Application for a non-material amendment following a grant of planning permission.

Number	
Suffix	
Property name	
Address line 1	Ravens Bank
Address line 2	Whaplode St Catherine
Address line 3	
Town/city	Spalding
Postcode	PE12 6SH
Description of site location must be completed if postcode is not known:	
Easting (x)	533934
Northing (y)	320004
Description	
Land adjacent Willowcroft

Erection of detached dwelling	
Reference number:	H23-0914-18
Date of decision	12/11/2018

Omission of chimney stack

Job No.:	Draw No.:	Stage:	Revision:
051804	PD02	Planning	P2

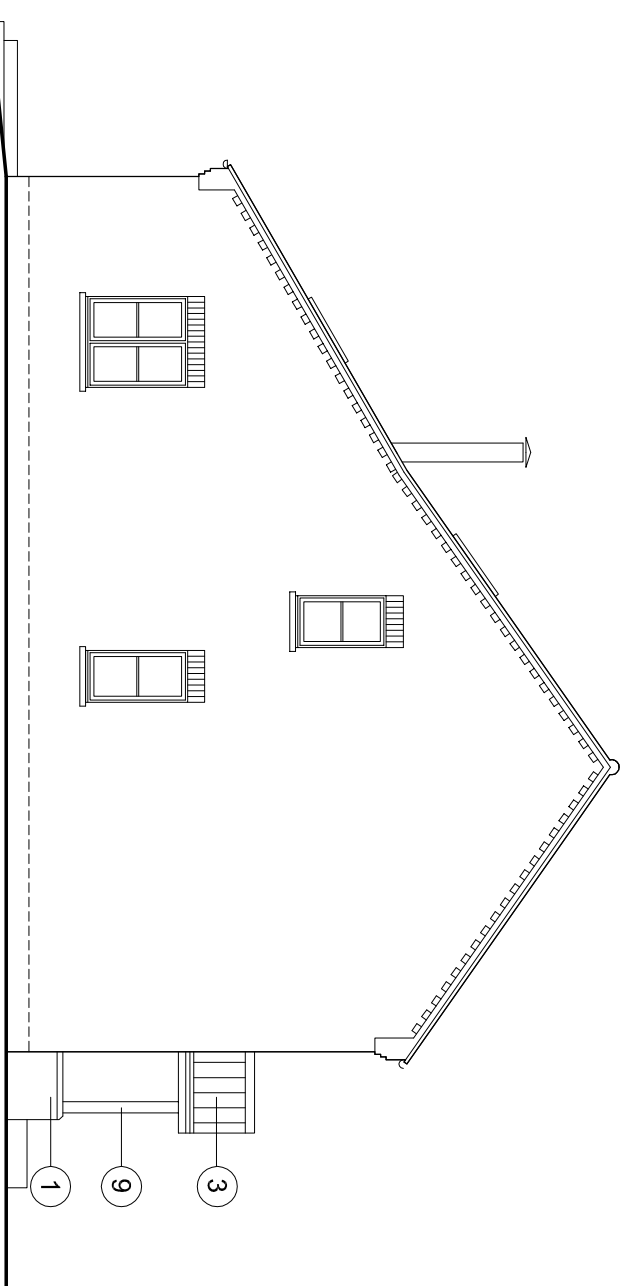
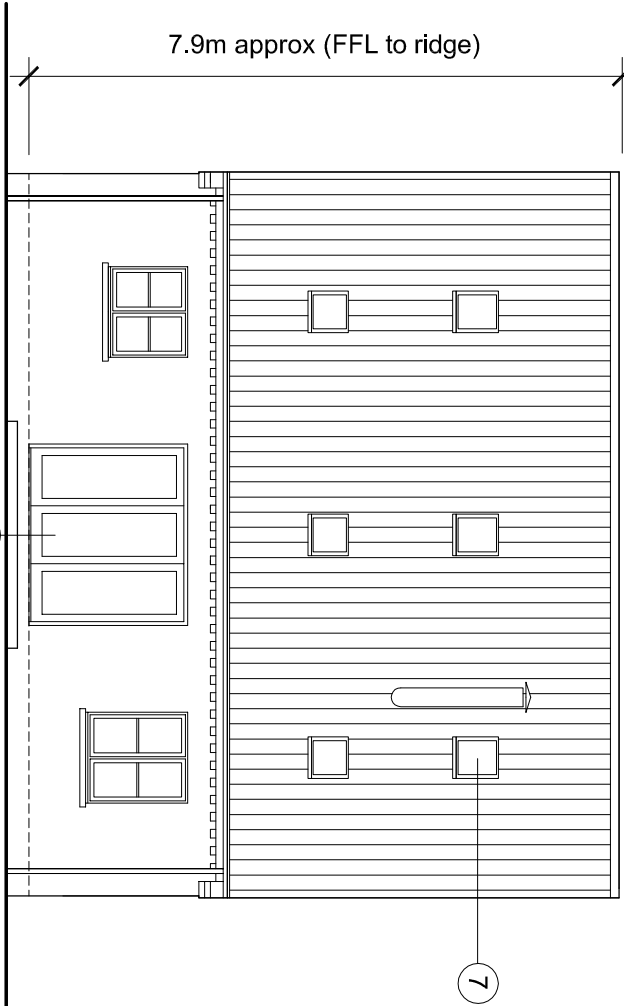
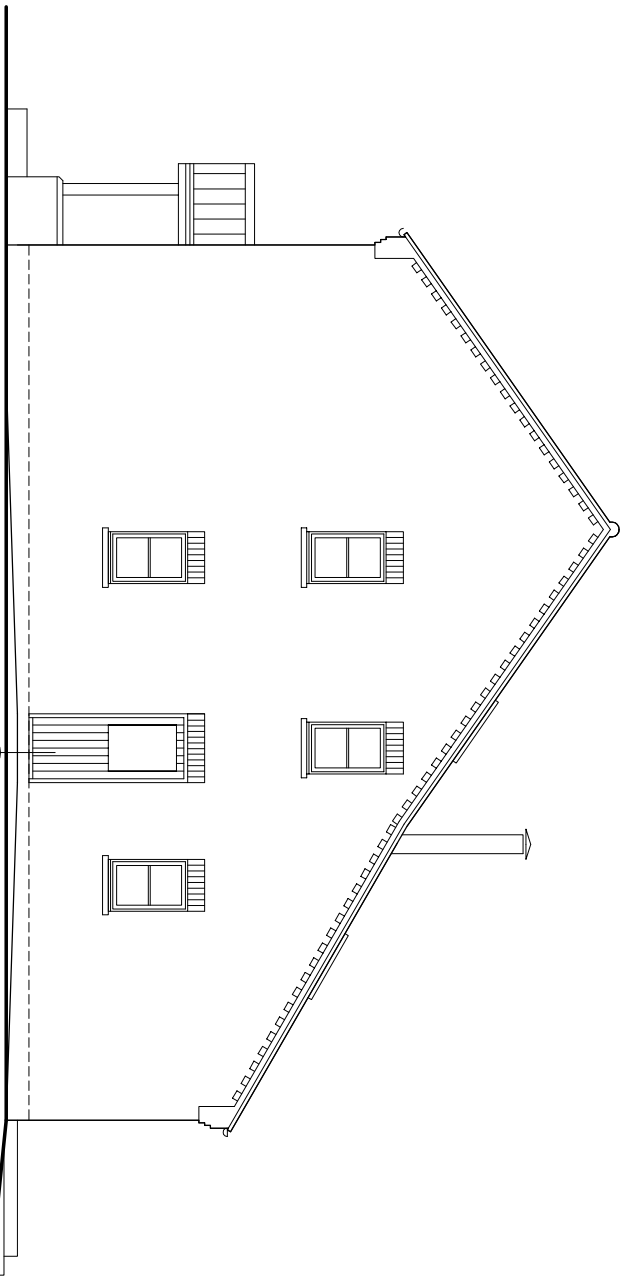
PD02(P1)

PD02(P2)

The applicant has chosen a method of heating which does not require a chimney stack.
